Medworth ISH5_18 May_PT3

File Name: Medworth ISH5_18 May_PT3

Figure 7.5
Operational noise Study Area - EfW CHP Facility

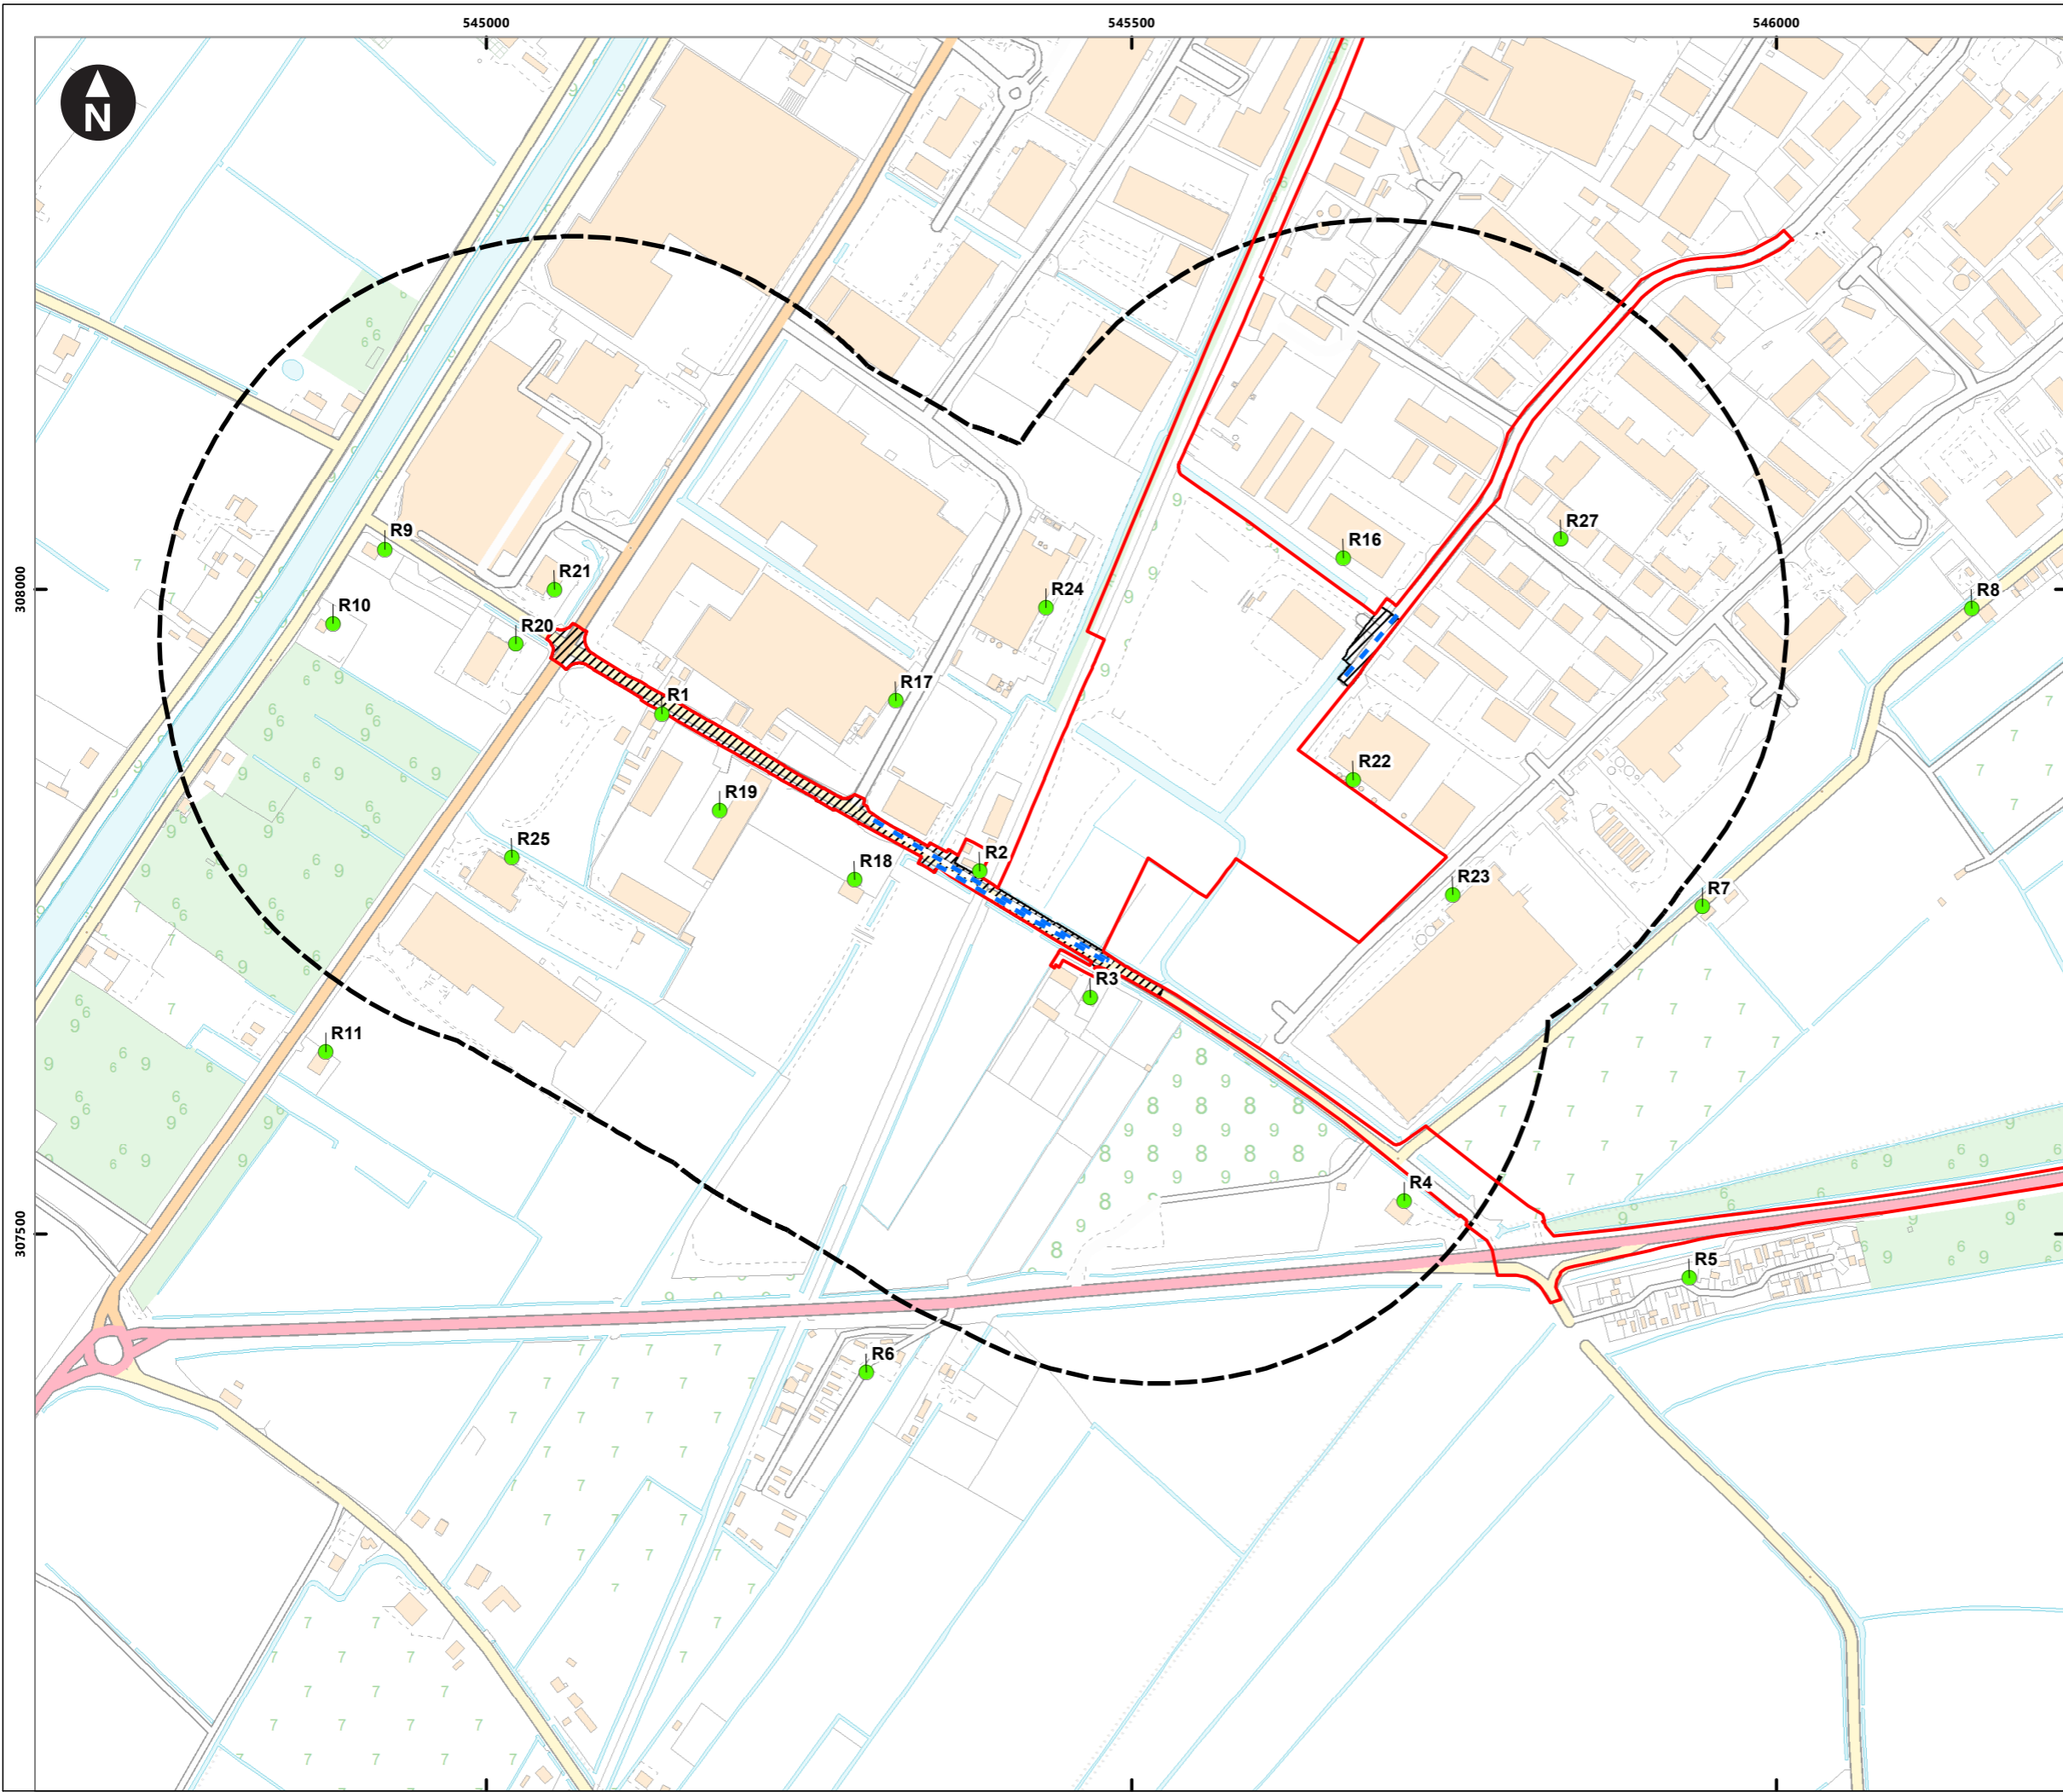
Right. In that case. Can you actually point me to a specific figure where that difference is highlighted in where I can see the location of our 11 to 15 and why it's separate from this table?

So you mean figure 7.5 in figure 7.1.

Right. In that case, I'm afraid I'm going to have to press on this point again because actually, according to the operational noise study area, um, we can see that that figure figure 7.5 includes, for example, R 13, which is right at northern edge of the um, green, um, operational noise study area that you have identified. Therefore, I'm still not 100% clear in terms of why these were not included as part of the assessment.

But in that case, can I please ask you to point me to the figure where that is clearly set out and where we can actually see the location of those boundaries and the location of those receptors?

We are just conferring the the answer to your question is that our 13 being on the the outskirts of the the study area, there are receptors that we have included in the assessment that are closer to the the works, to the operational noise from the site itself that are not significant. And so we haven't drawn the assessment out further because if they're not significant at those locations closer to the site, they won't be significant outside.

Within the discussion of methodology in AP 034, we discussed the fact that we were looking at the nearest receptors to the site in all directions. Our 13 is close to the

line of roots, and so we've included that as a construction noise receptor because it's closest to the the works as they progress along. But it is not an operational noise receptor on the basis that it's much further from the works than from the operational site than receptors that we have assessed in between it and the site itself.

So the standard practice in operational noise assessment is that you look to determine the the nearest receptors sensitivity and were they determined as being unacceptable. The study area is expanded to include more receptors to determine where the the limit of acceptability lies.

And because the closest receptors in all directions, with the exception of nine and ten Newbridge Lane, were were not significant. That's where we kept the the assessment focused in on.

Um, that may not be present in the report, but it is a standard approach. It was agreed with the Fenland District Council. Um, consultant who where, where we did agree receptor locations for for assessment. And we can provide additional information in a.
